PETITION NO. 85-53(c) HEARING DATE October 14, 1985

REZONING PRE-HEARING REPORT

PRE-HEARING STAFF ANALYSIS*

## SITE PLAN

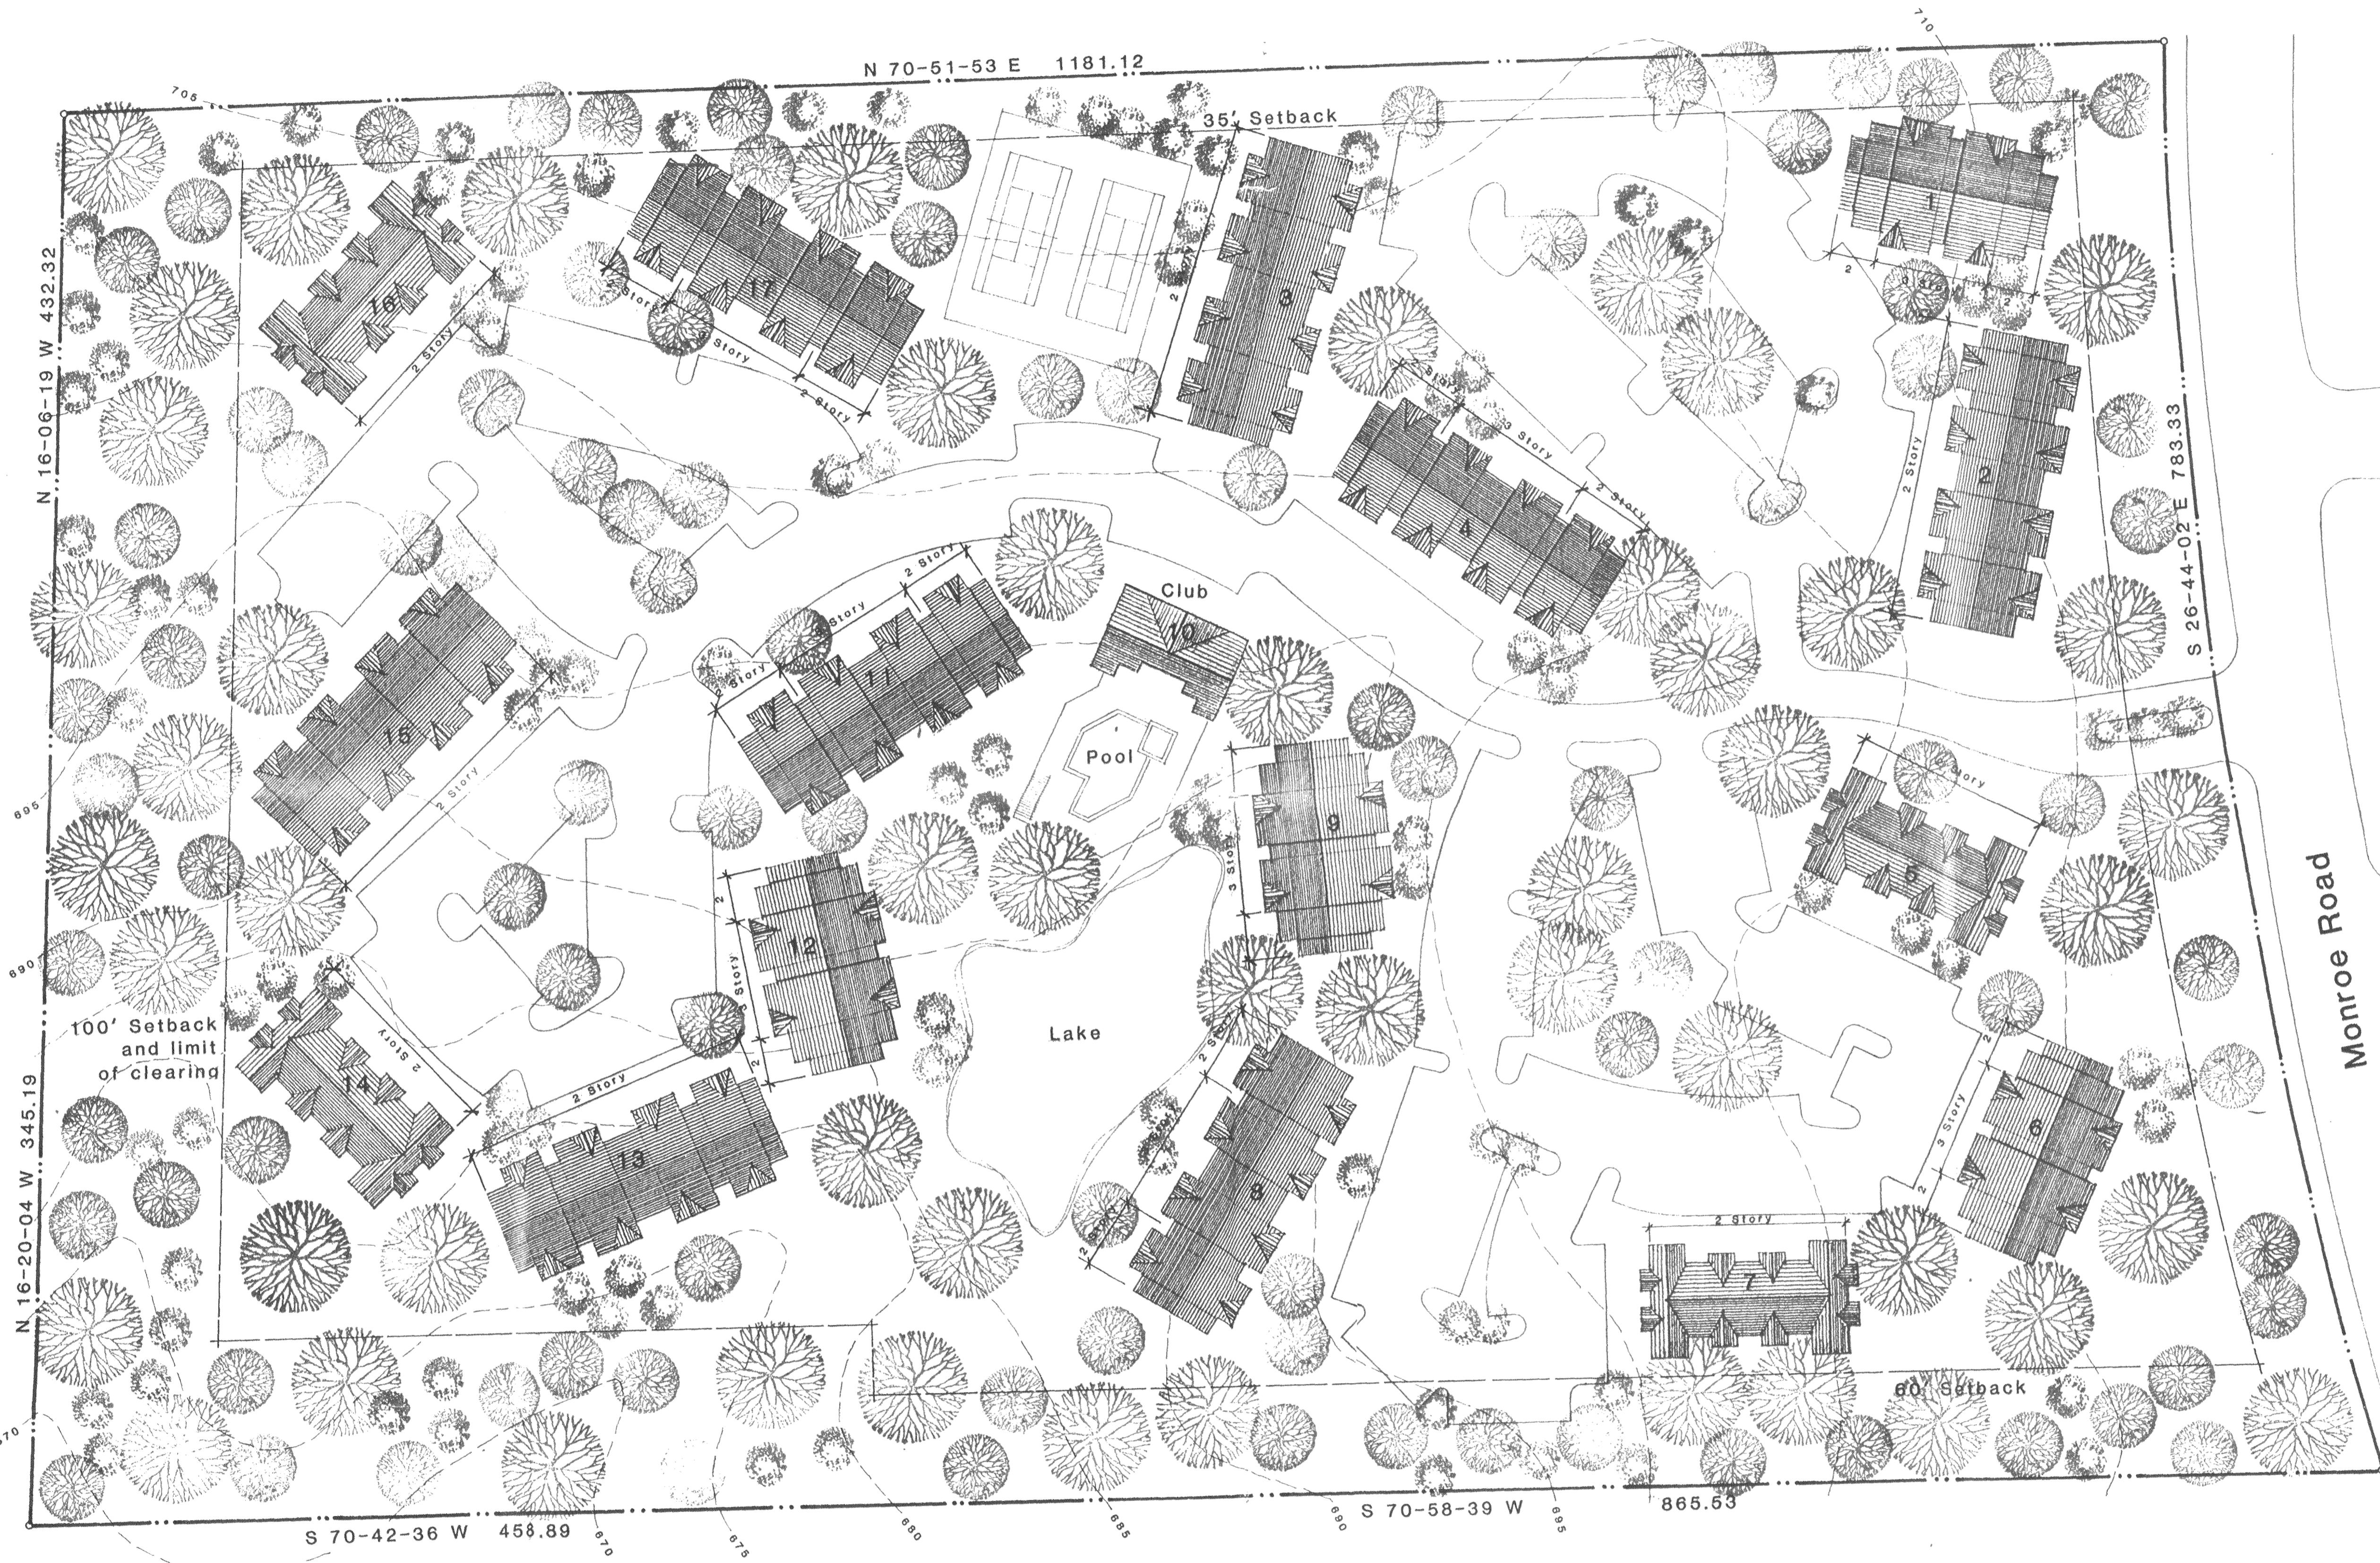
4. There are many aspects of the conditional site plan which are important to evaluate. First of all the driveway access to Monroe Road should be shifted somewhat southerly to line up with an existing driveway on the other side of Monroe Road. In addition it would be desirable to obtain an additional right-of-way along Monroe Road. Further the plan establishes various setback/buffer areas around the site. Of critical concern is the area closest to single family areas which have already developed. In those areas a 75 foot setback and limit of clearing area is shown. However it is believed by staff and by the neighborhood that a buffer which is somewhat larger (perhaps 100 feet) would be more appropriate and to clearly label the site plan where the limits of no clearing will be observed. That is a little difficult to ascertain on the current plan.

5. The southerly border also observes for the most part a 60 foot setback, but part of that is penetrated by a parking lot. Either the parking lot should be screened entirely from view or moved back so that a solid 60 foot barrier is retained from it and the adjoining property line. Although storm water detention is not required there is a note on the plan indicating that there will be provisions for that, but no location for that is shown. That also would be desirable information to have placed on the plan. Finally, the proposed density of 12.7 is somewhat higher than the densities approved for other projects recently.

- Dick — Will stub street (Wagon Hill Rd.) be extended?
- No grading in 75' setback?
 - Are 1.8 parking spaces per unit adequate (Note about parking)
 - Additional Row on Monroe 50' setback from new Row line
 - Jennis Court fence can not be over 6' high, Court is in reg. yard.

Fire — Adequate fire hydrants should be provided. Turn arounds should have proper turning radius

Warren — Plan works ok, but parking lots are too wide — reduce to 58'

Bill Coyle — 20' more Row on Monroe Rd + left turn lane
line up entrance w/ southerly Pci + Pay (?) entrance

additional screening along
single family edge
snow stormwater detention

Note #8 on site plan? what does that mean?
